TfNSW reference: REN25/00041/003

SSD-70279722, Mount Piper to Wallerawang Transmission, Response to Environmental Impact Statement

- Environmental Impact Statement (EIS) prepared by Transgrid, dated 21 August 2025
- Traffic and Transport Assessment (TTA) i.e. Traffic Impact Assessment (TIA) prepared by GHD Pty Ltd, dated 18 August 2025.

Figure 3.9 Traffic survey volumes – Boulder Road / Castlereagh Highway intersection

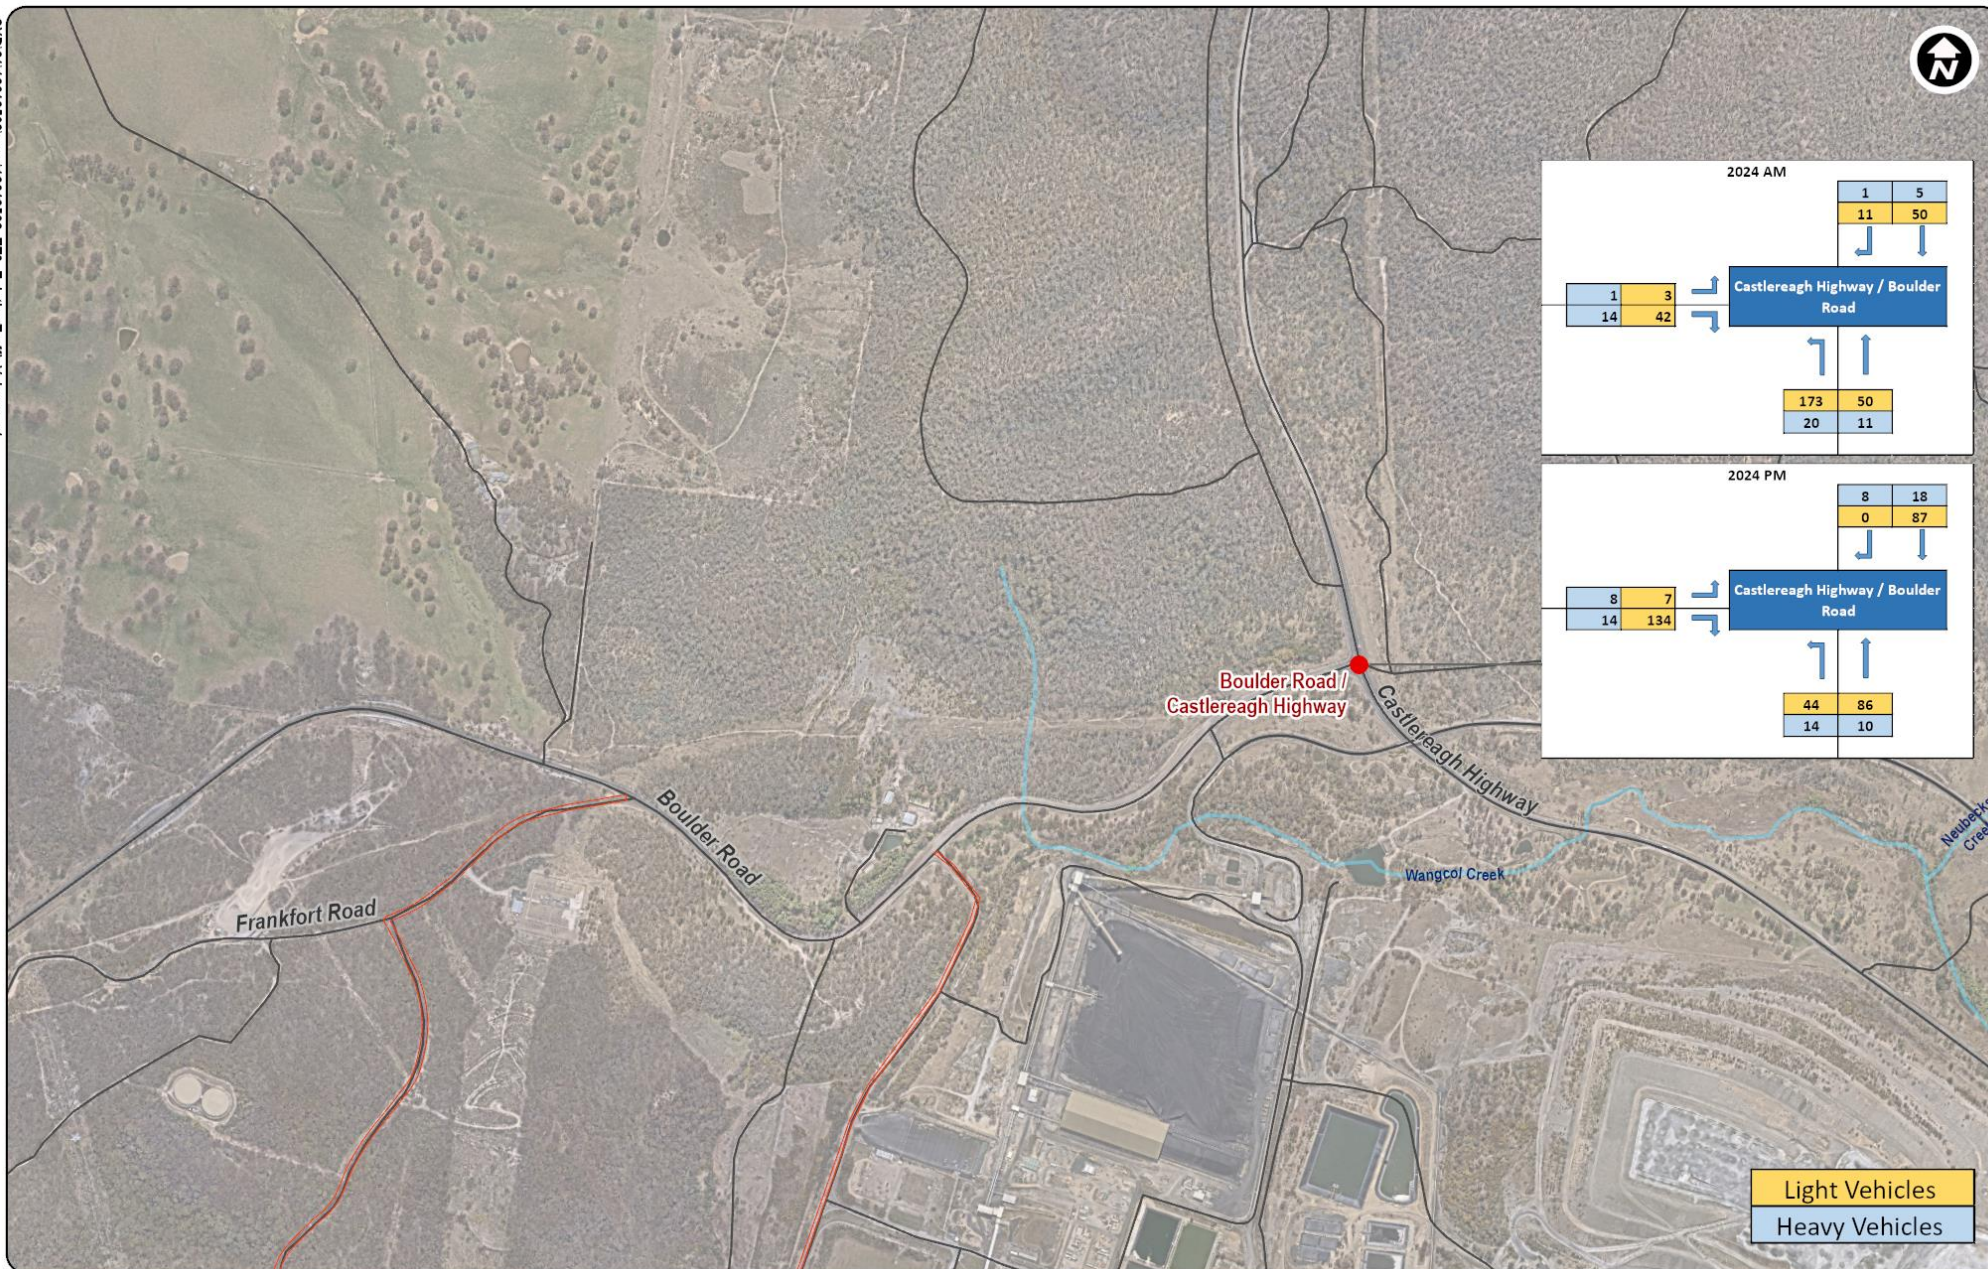
- c. The turning volumes at the AM/PM peak hour for each intersection, as provided in Figures 3.9, 3.10 and 3.11, do not align with the turn warrants assessment graph provided in the tables provided in Section 4.2.1.2 of the TTA for each intersection and access track with direct connection to the state road network. Review the turn warrant assessments in relation to this point and revise to align with the correct turning volumes and distribution assumptions.

- d. A clear comparison between traffic volumes as impacted by the project and background traffic (inclusive of cumulative impacts and growth rates) is to be presented in diagrams depicting volumes for each intersection, similar to Figures 3.9, 3.10 and 3.11 in the TTA. To differentiate between the existing background and the turning volumes from the project traffic volumes associated with this project, construction traffic volumes, and allow for ease of comparison.

Figure 4.3 Proposed heavy vehicle access routes

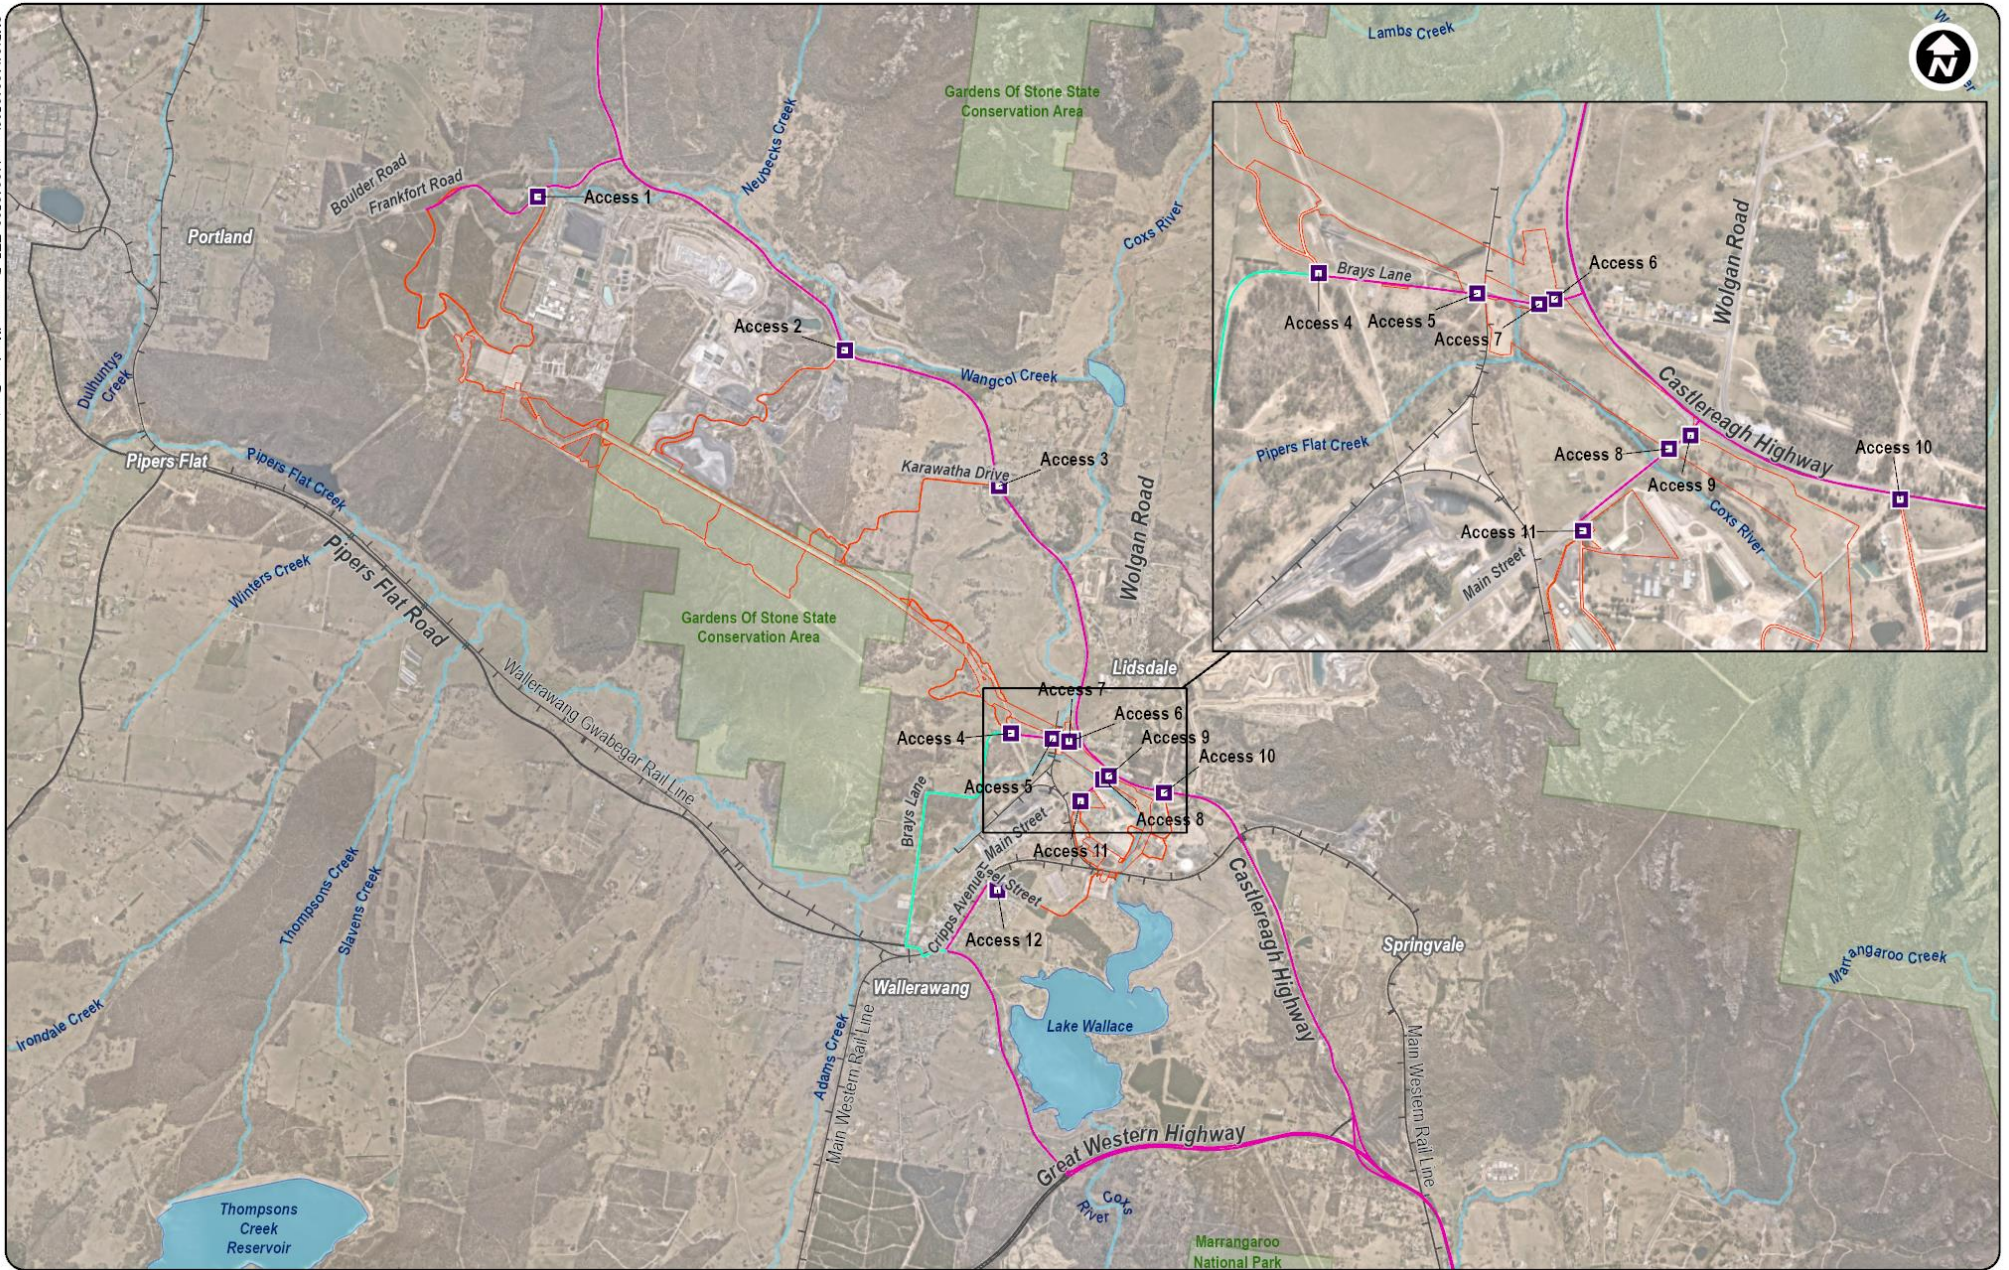
- a. It is noted that site access routes are expected to originate primarily from Sydney and Newcastle, with some transport from Orange or Bathurst as required. However, the EIS and Traffic and Transport Report do not include a detailed map of the proposed Heavy Vehicle and OSOM routes to access the site. Additionally, the documents do not provide any information on suggested routes that may cross Country Regional Network (CRN) railway infrastructure, such as level crossings, overbridges, or under bridges.

Details of the proposed access route from the port/origin to the site is to be included within the revised TIA, clearly identifying any CRN infrastructure along the route. If any CRN infrastructure is impacted, the amended documents must be referred to TfNSW and UGL Regional Linx (UGLRL) for review and approval. Furthermore, the applicant must comply with the transport management and safety requirements of both UGLRL and TfNSW for any matters involving the CRN corridors.
